Subject: Objection to Project Atlas Data Centre, 10 Roberts Road, Eastern Creek, SSD-101067971

Lane Cove Responsible Planning objects to the proposed Project Atlas Data Centre at 10 Roberts Road, Eastern Creek.

Figure 4 Sensitive receptors and population density surrounding the Proposal site

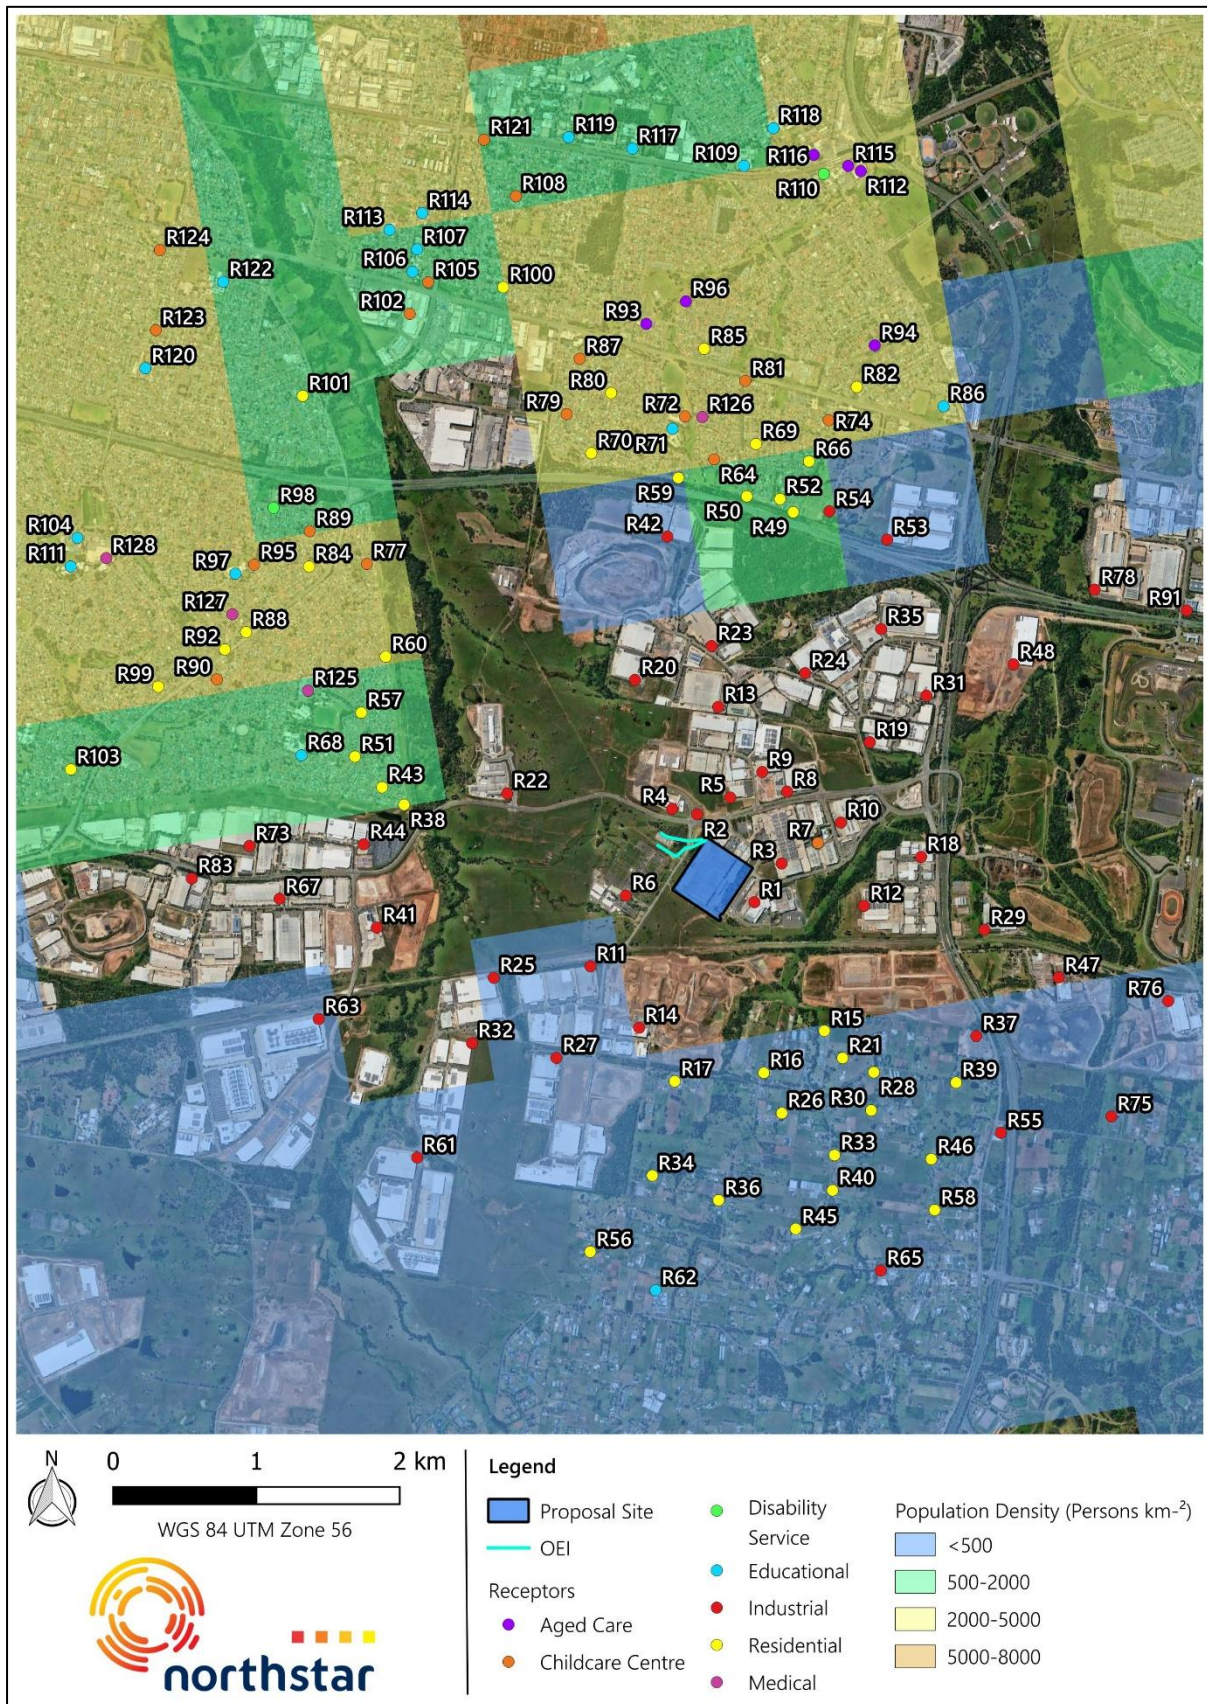
The AQIA states that sensitive receptor locations are part of the assessment and includes a figure showing sensitive receptors and population density surrounding the proposal site. However, representative modelling is not enough for a project of this scale. The Department should confirm the real world location of all sensitive land uses and require revised modelling if closer or more sensitive receivers are identified.

Figure 6 Locations of proximate neighbouring air emission sources

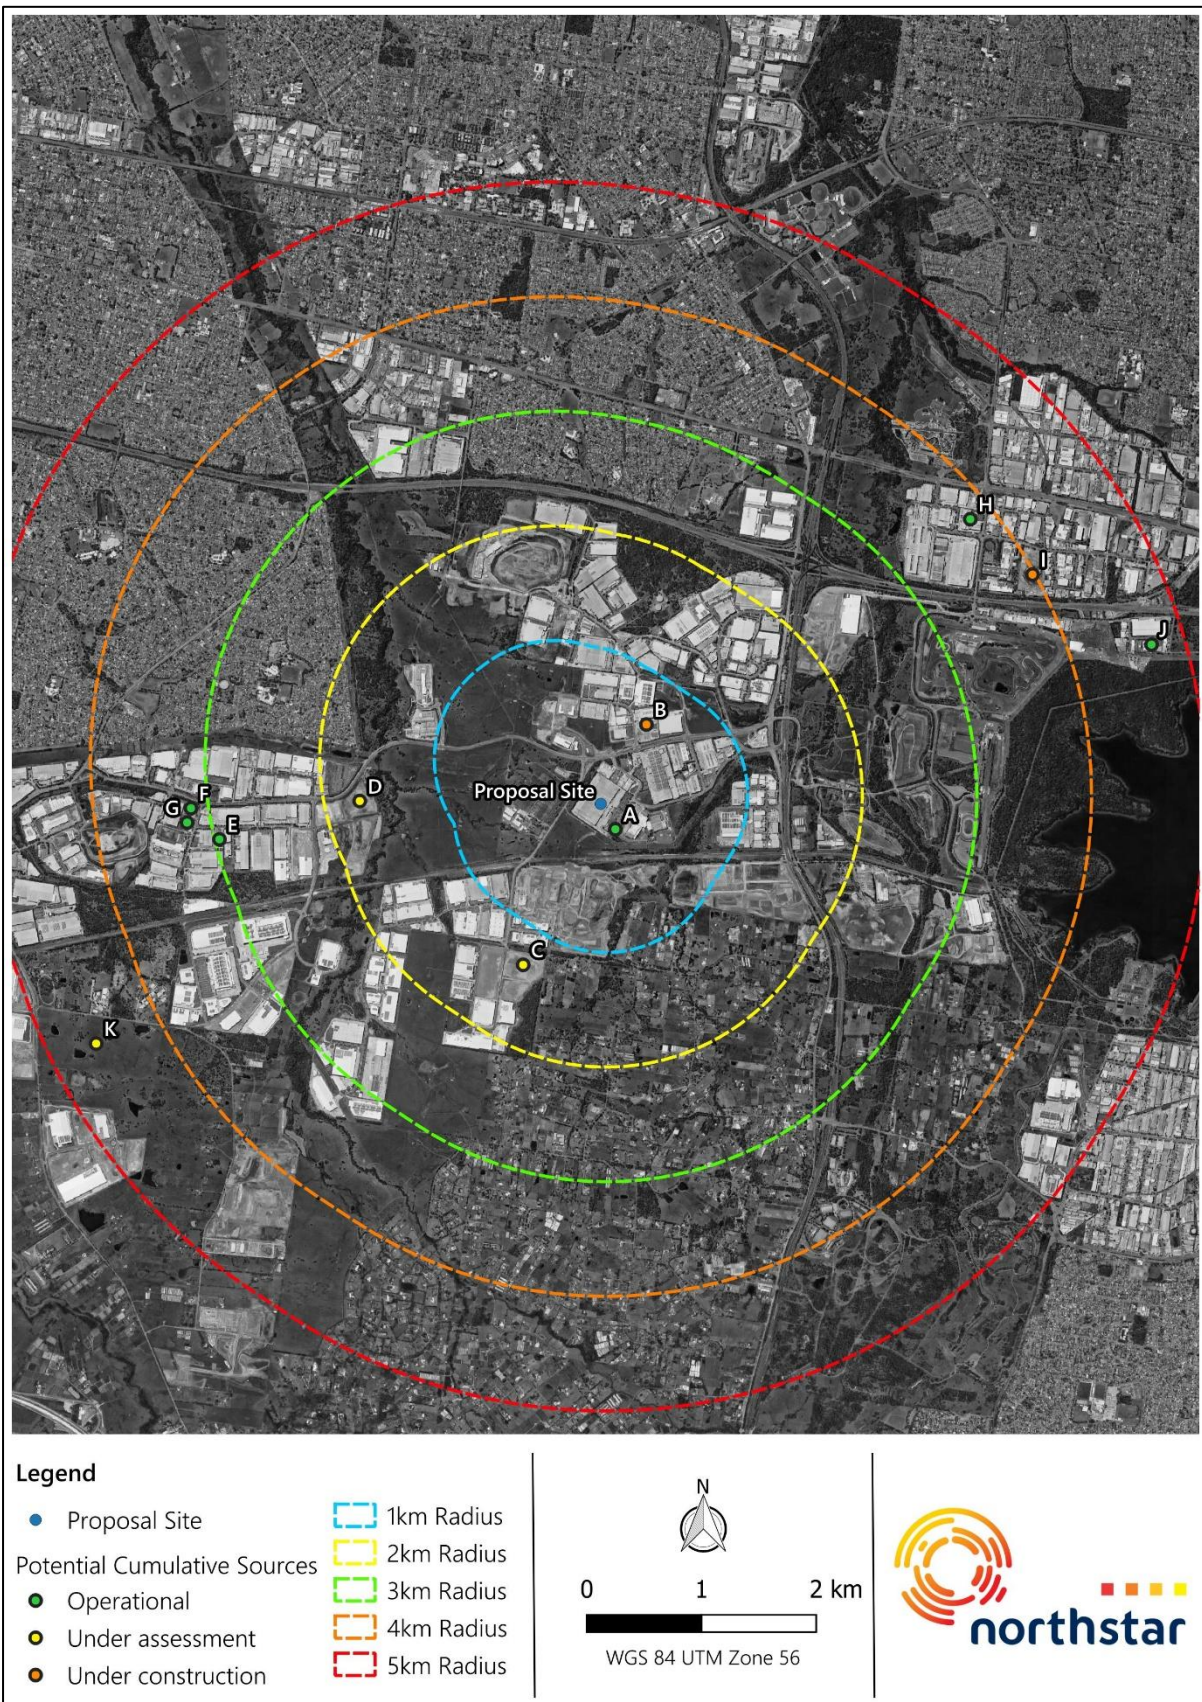
The AQIA identifies nearby data centre projects with potential cumulative air quality impacts. It identifies the CDC Data Centre at 17 Roberts Road, only 0.04 km from the proposal site, and states there is potential for cumulative operational impacts between that 169 MW facility and the proposed 348 MW Project Atlas, particularly during emergency conditions. It also states that the proposal may result in significant cumulative air quality impacts.

The AQIA also identifies NEXTDC S4 at Horsley Park, with 232 MW power and 98 generators, and states that simultaneous backup generator operation with Project Atlas during widespread grid outages may temporarily increase local emissions. It again identifies the potential for significant cumulative air quality impacts.

The Department should require a full precinct wide cumulative impact assessment covering all existing, approved, under construction and proposed data centres in the Eastern Creek, Horsley Park and Erskine Park area. That assessment should cover air quality, noise, low frequency noise, generator testing, emergency generator operation, commissioning, electricity demand, water demand, construction overlap, traffic, fire risk, heat, ecology and social impact.
